CITY OF ALBUQUERQUE

September 9, 2014

Re: McDonalds, 5700 McMahon Blvd NW
Request for Permanent C.O. –Not Accepted
Temporary C.O. –90 Day Accepted
Engineer's Stamp dated: 3-20-14, (A11D011B)
Certification dated: 9-4-14

CONCEPTUAL GRADING AND DRAINAGE PLAN

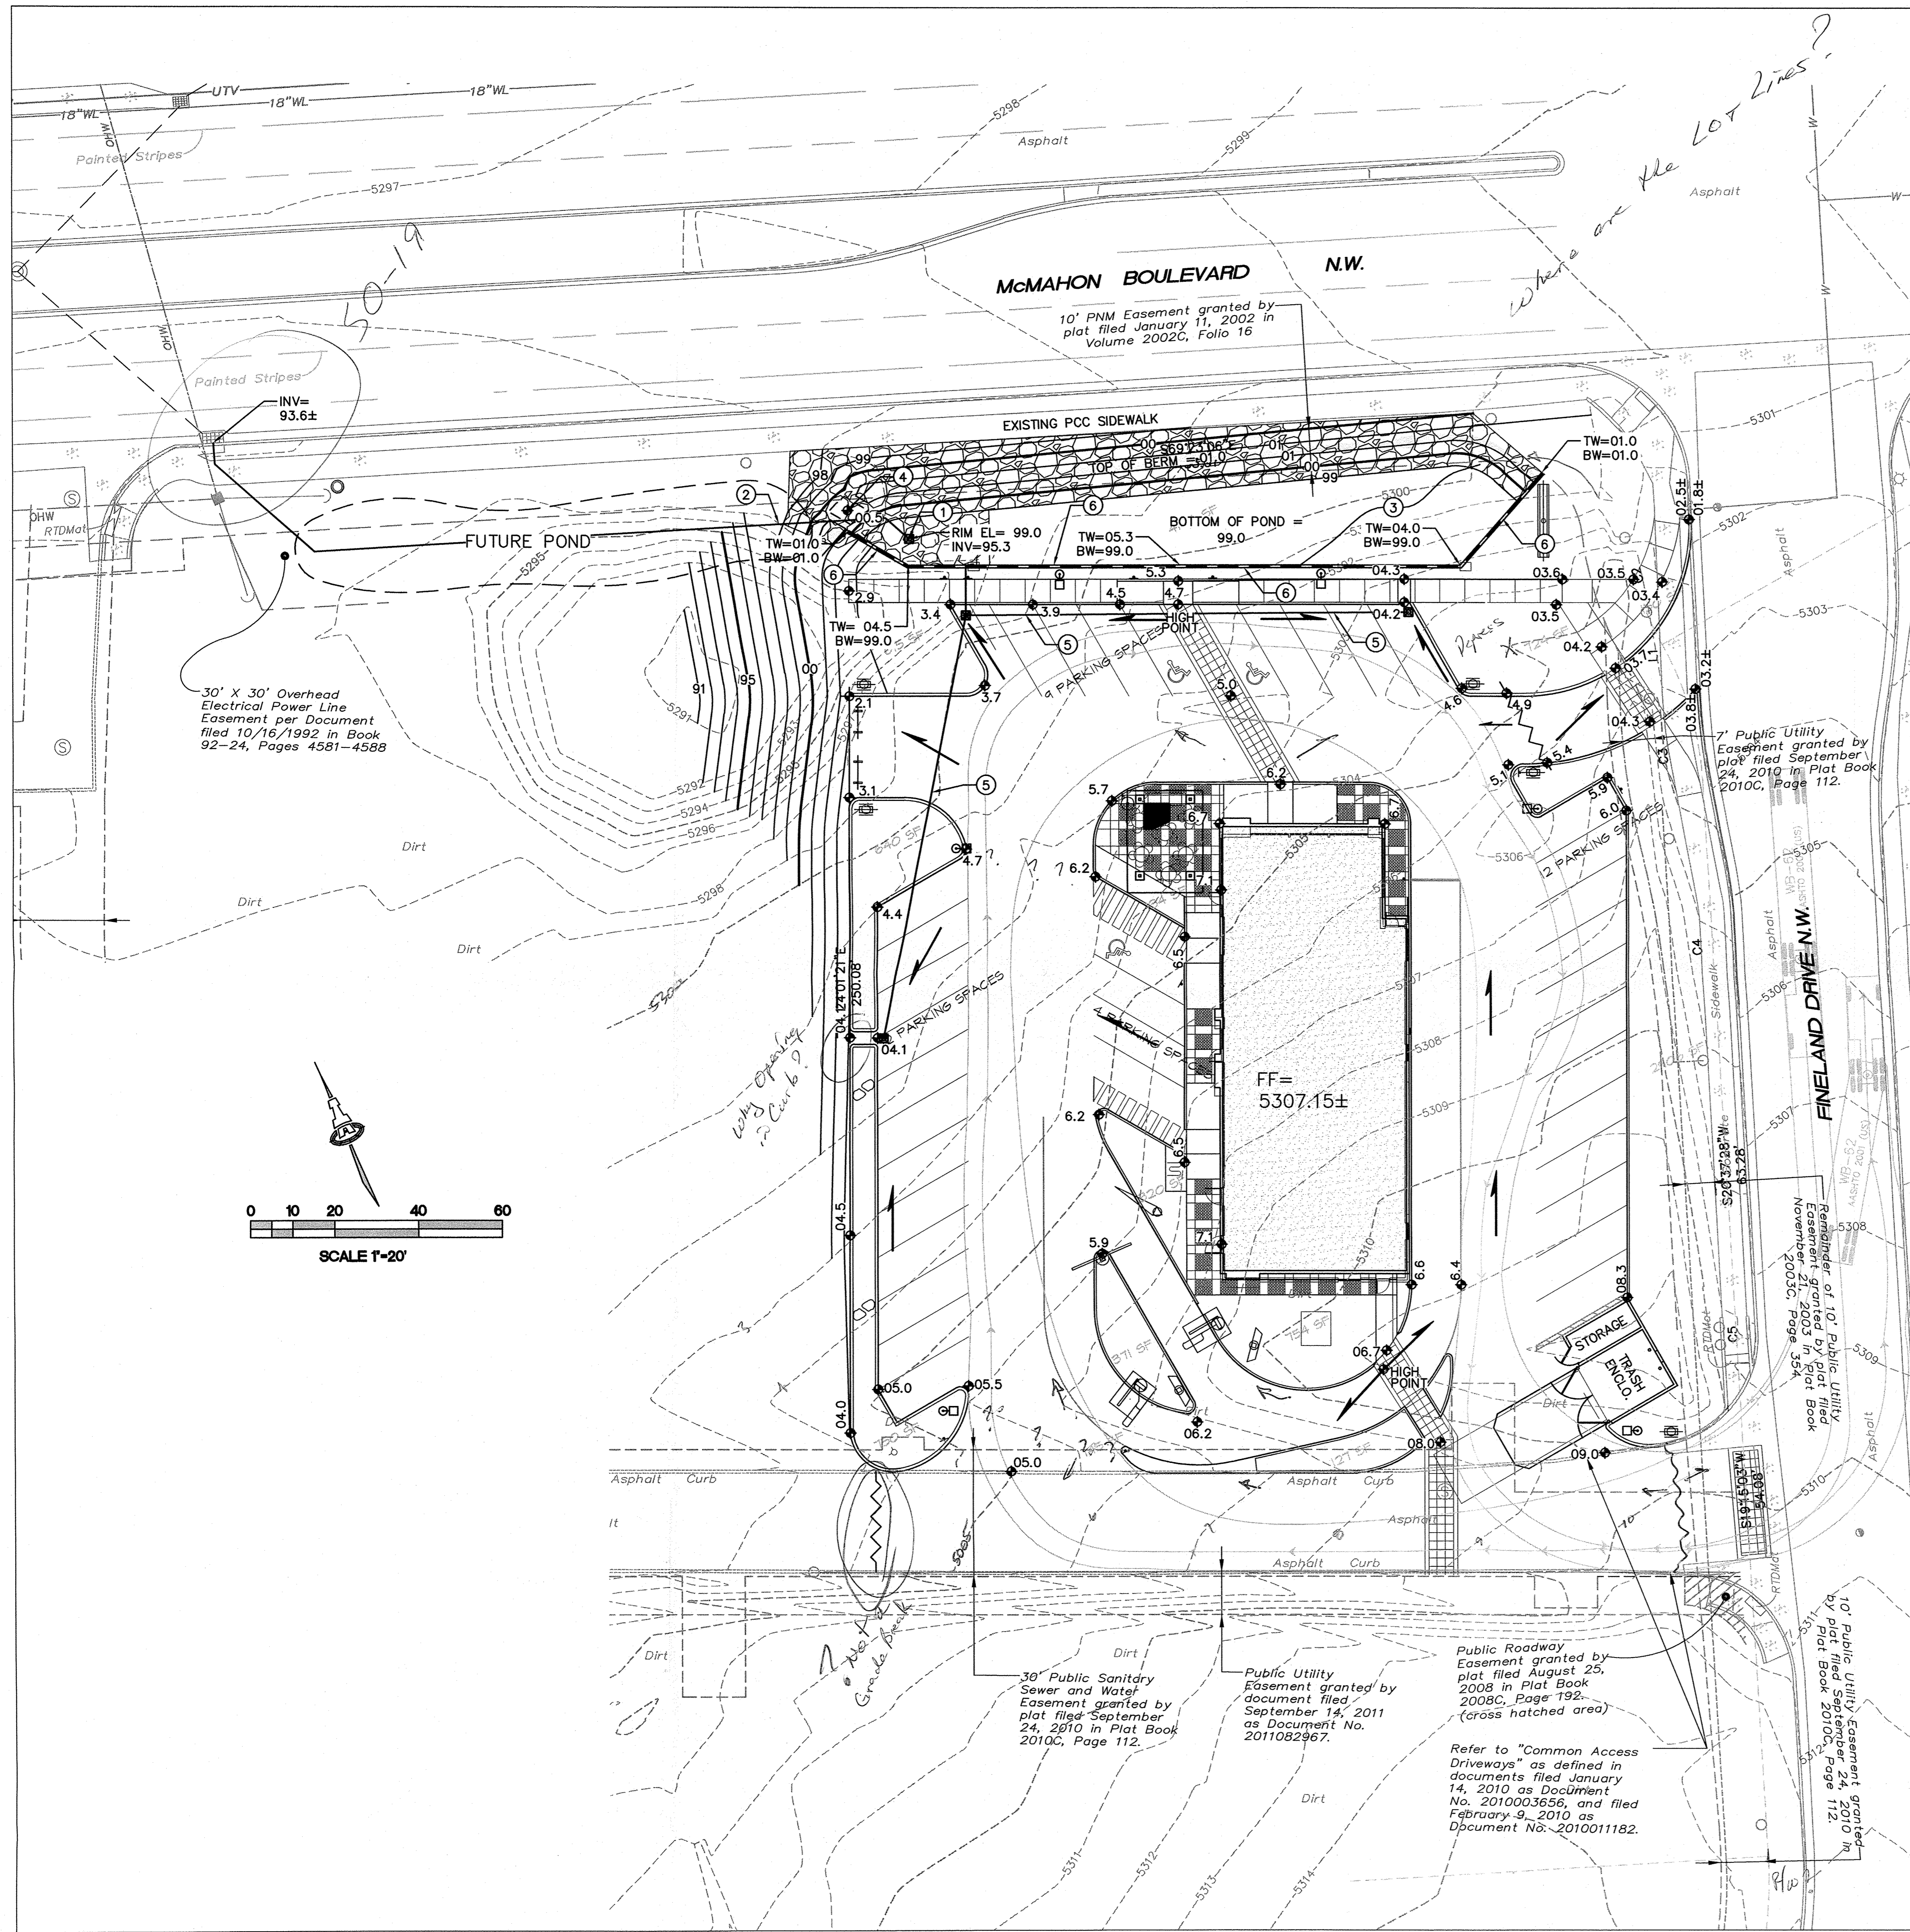
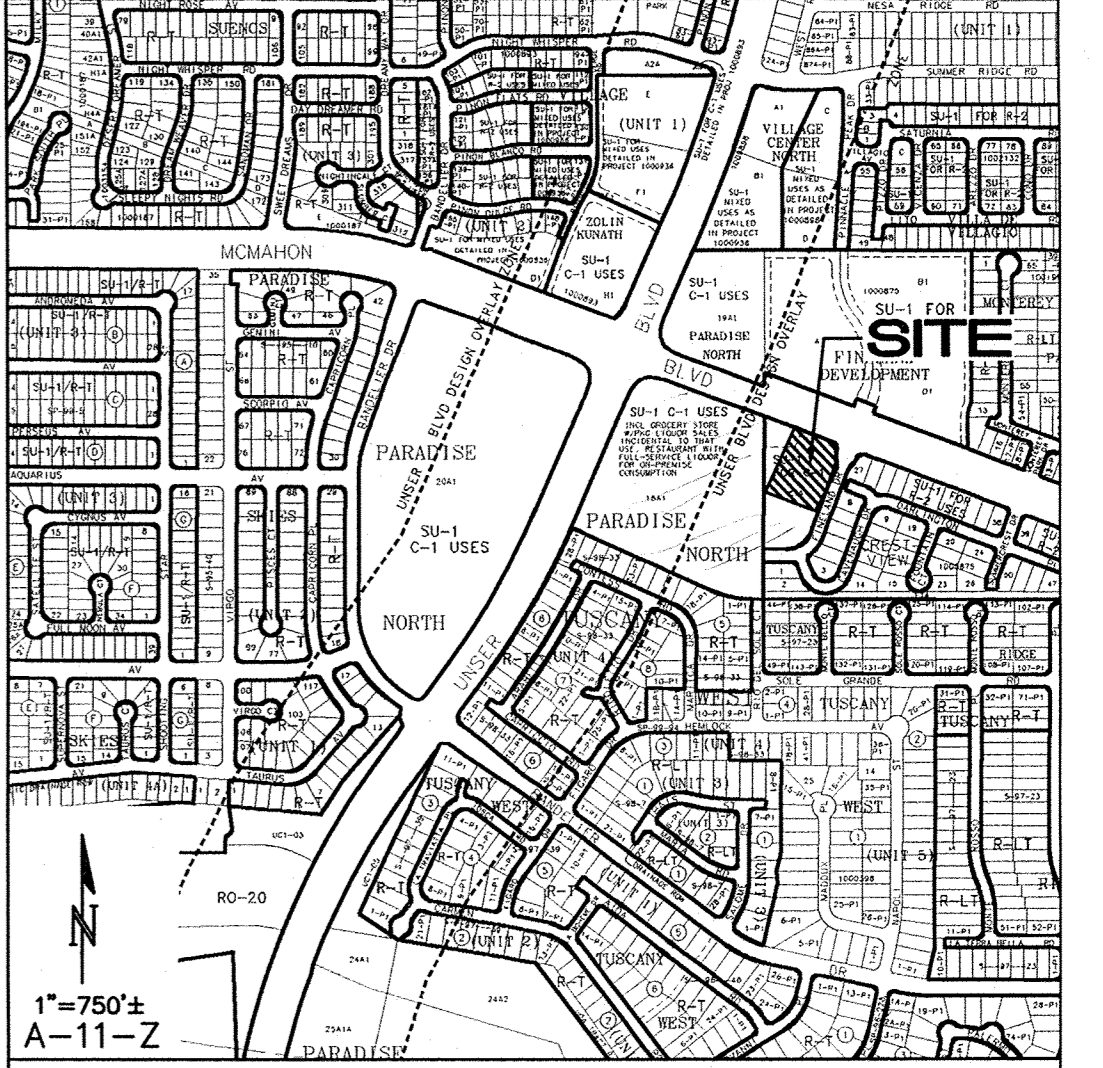
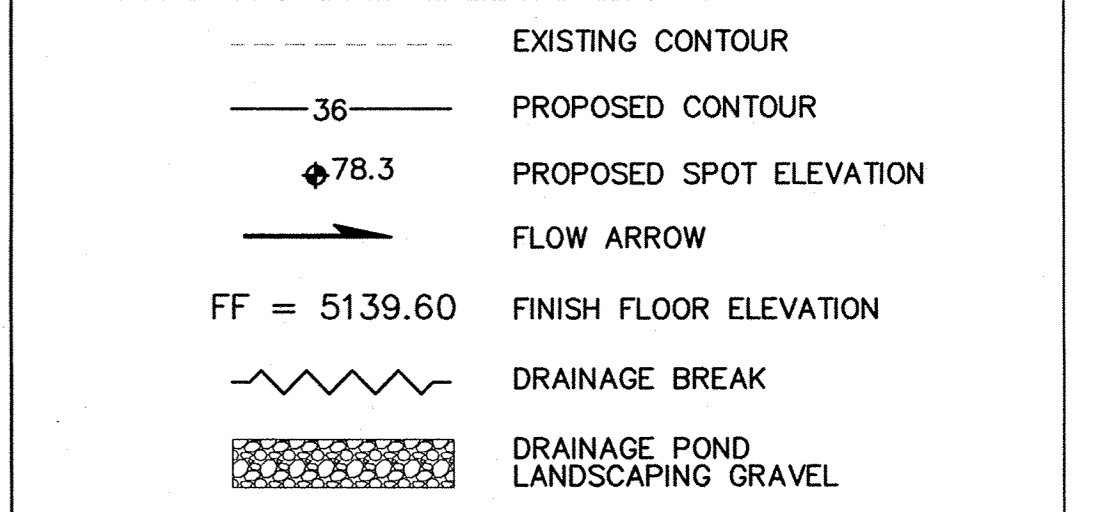
1. The berm that forms the north side of the pond ties into the 4x4 box, rather than going around it. Should this berm be entirely on this site?
2. The rip-rap for the emergency spillway is dumped cobble rather than grouted and is not on the spillway.
3. The curb was not built at the end of the drive for Basin A-9 and the curb cut is not built. The curb cut should probably be moved uphill 6 to 10 feet so the water enters the inlet.
4. The top of the 4x4 riser appears to be too high.
5. Provide a photo of the orifice plate installed in the riser. If the opening on the east side of the riser meets the intent of the orifice plate then include this information on the certification.
6. The pond volume is to be included as part of the certification.
7. Sheet C8.1 is to be included as part of the certification since it shows the onsite storm drain.
